KITTITAS COUNTY COMMUNITY DEVELOPMENT SERVICES

RE: Biddle Short Plat (SP-14-00002)

Enclosed are the comments received regarding the Biddle Short Plat (SP-14-00002) during the comment period:

BIDDLE SHORT PLAT		
PREPARED FOR RAY BIDDLE		
A PTN. OF THE SE 1/4 OF SEC. 5 & A PTN. OF THE NE 1/4 OF SEC. 8 TOWNSHIP 19 N., RANGE 16 E., W.M.		
KITITITAS COUNTY	DATE	JOB NO.
DWN BY G. WEISER	07/2014	14052
CHKD BY D. NELSON	SCALE 1"=100'	SHEET 1 OF 2

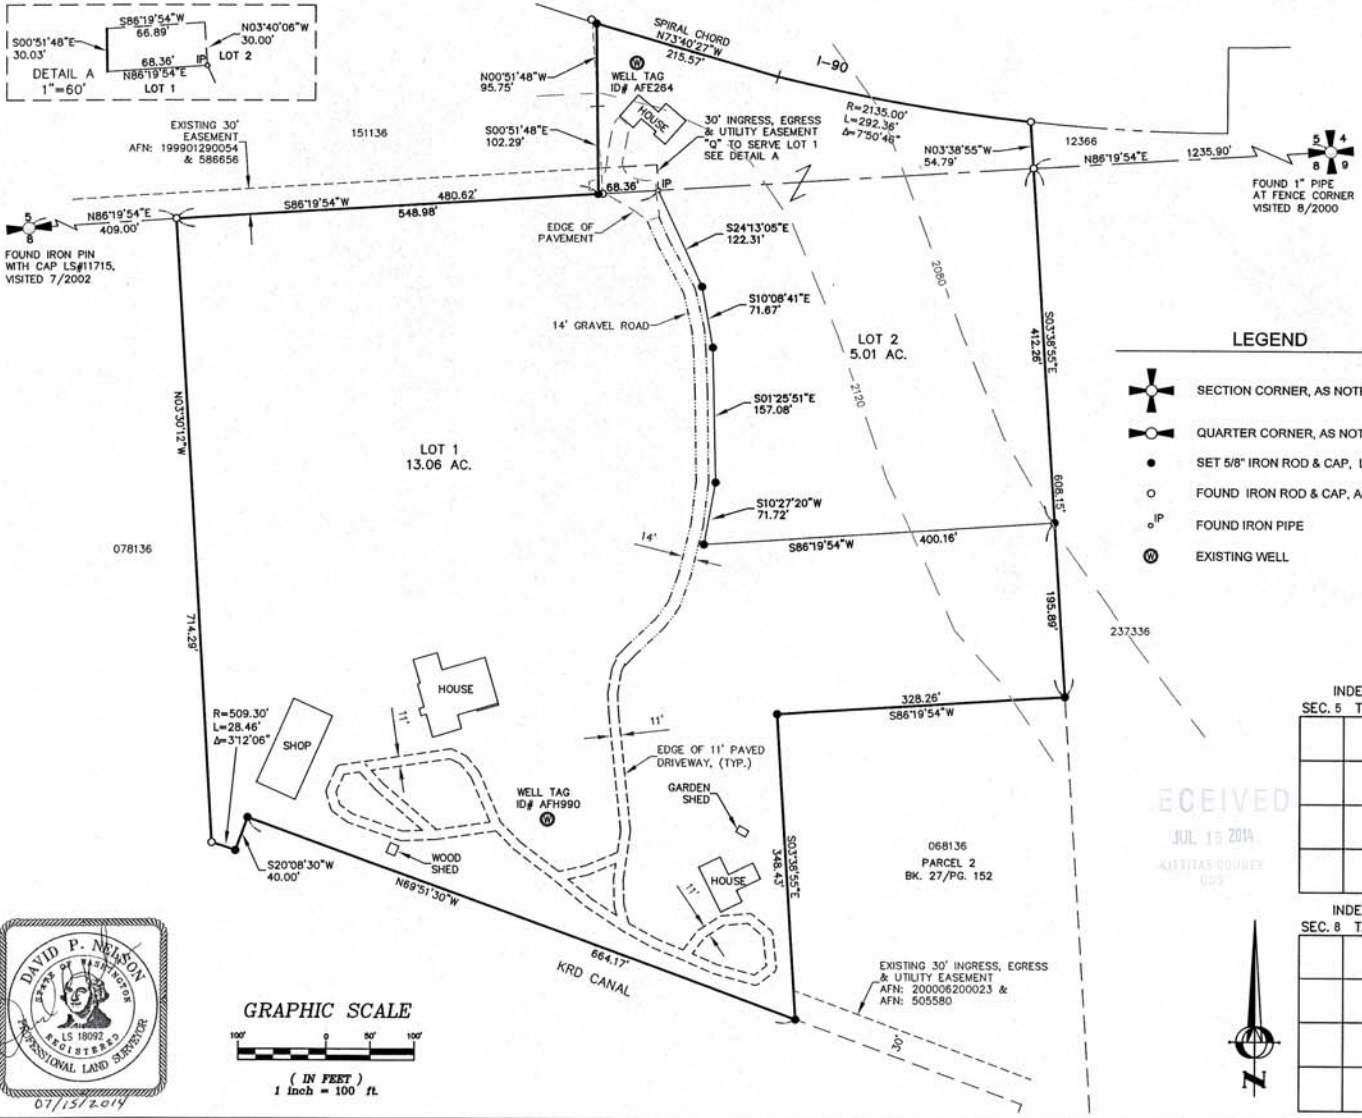
- Ensure that boundary line adjustments do not infringe upon existing structures, to include propane tanks, etc.
- Ensure adequate access for fire apparatus. Any driveways or access points created based off the new lot configurations shall comply with Kittitas County Code 20.02.030.
- All future development must comply with the International Fire Code.

- The project is adjacent to Interstate 90 (I-90), a fully-controlled limited access facility with a posted speed limit of 70 miles per hour. WSDOT has acquired all access rights to the highway. Direct access to I-90 is prohibited.
- I-90 is an essential public facility with existing traffic noise. The proponent and future residents should expect traffic noise to continue to grow into the future. It is the proponent's responsibility to dampen or deflect any traffic noise from the highway.
- Stormwater and surface runoff generated by this project must be retained and treated on site and not allowed to flow onto WSDOT right-of-way.

1. Road Standards Requirements: If the owner wishes to not improve the road to private road standards, a variance must be applied for. Otherwise, the serving roadways must be constructed to Low Density private road standards and certified by a licensed engineer prior to issuance of a building permit. The variance must be received prior to final approval of the short plat.
